Response to Planning Application

From: Arun District Council Greenspace

Application ref: F/5/22/DOC

Location: Wicks Farm Ford Lane Ford BN18 0DF

TITLE Proposed Site Layout Plan
 14/06/2022
 SCALE 1:2000 @ A3
 PROJECT No. 23482
 REPORT TYPE
 DATE 03

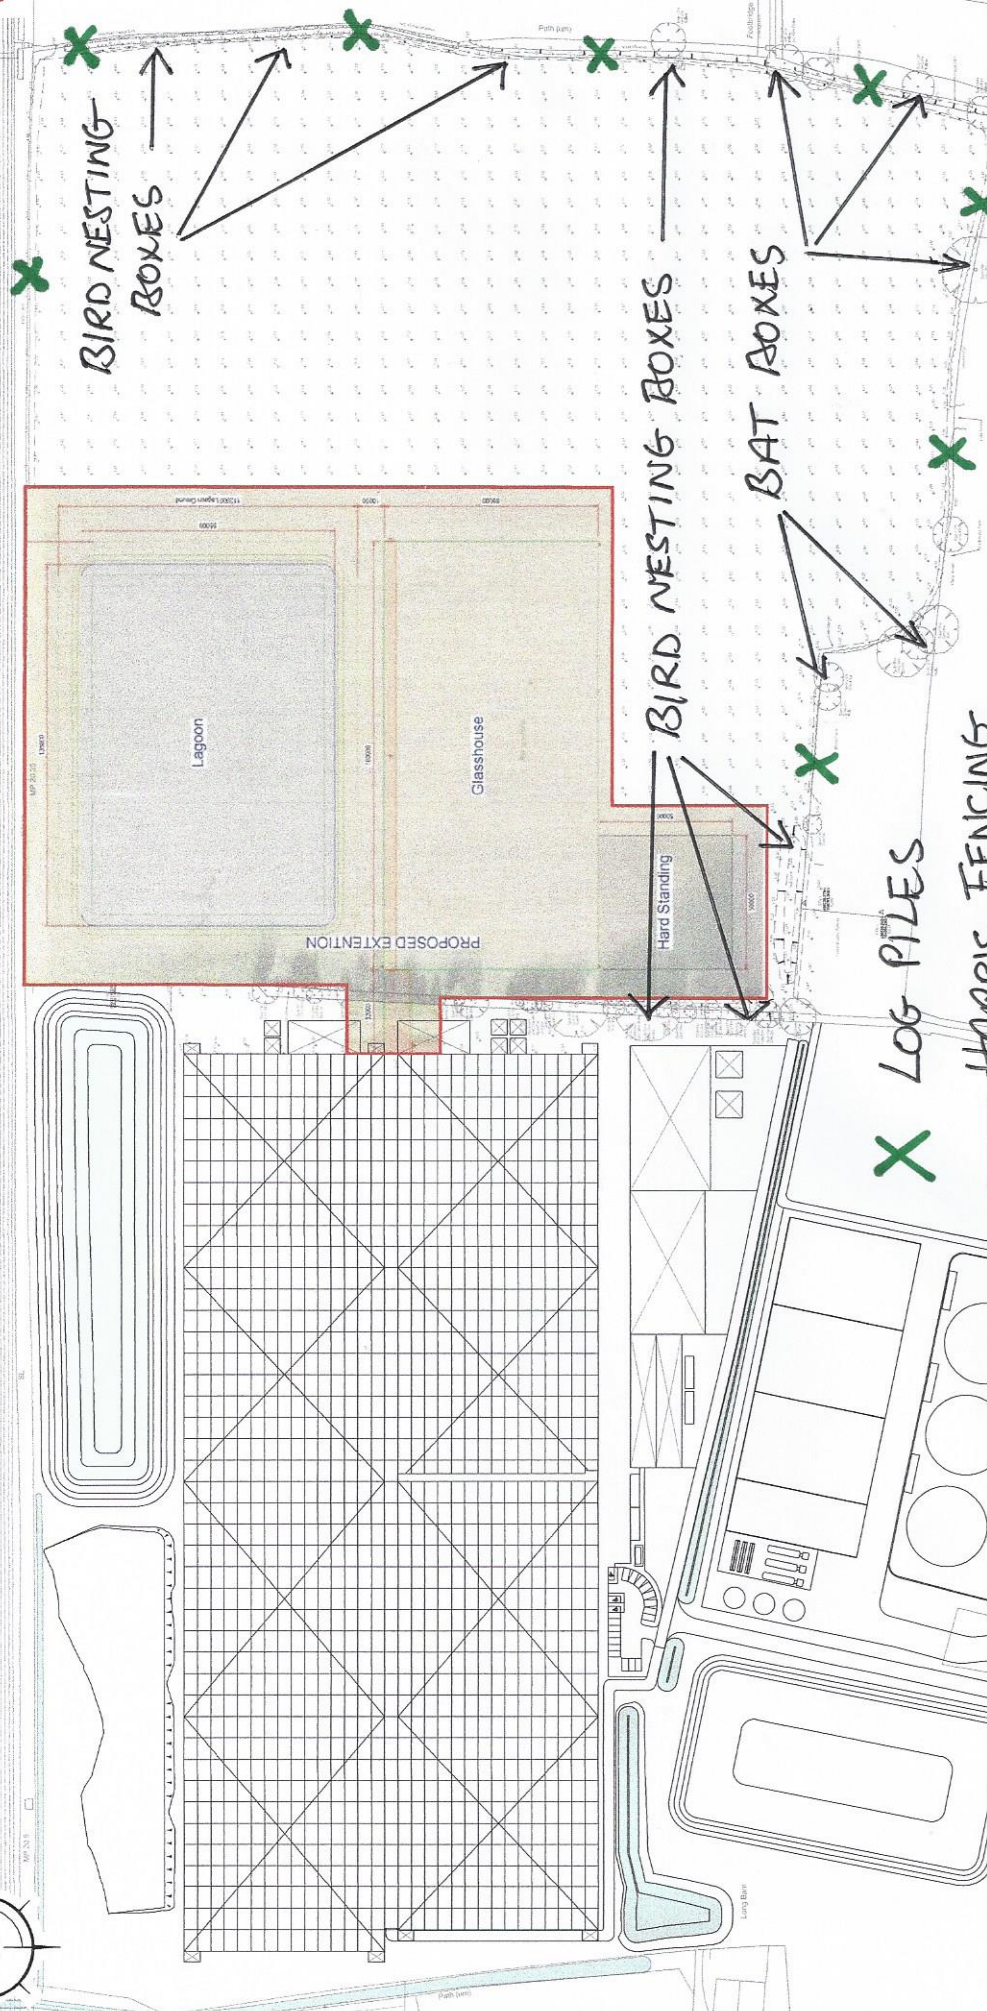
The application has not provided sufficient detail in plan form detailing species choice, actual quantities, planting densities and size at time of planting of the hedge infill and screening proposals. This information

is required to be submitted for approval in plan form, with detail of existing to be retained green infrastructure so that a clear picture of the proposals can be seen.

Further detail required to show planting proposal quantities, size and species of the detailed proposed 'gaps in existing hedge rows will be planted with native species during the autumn of 2022' Recommend that this information is submitted before approval of condition 6 could be recommended.
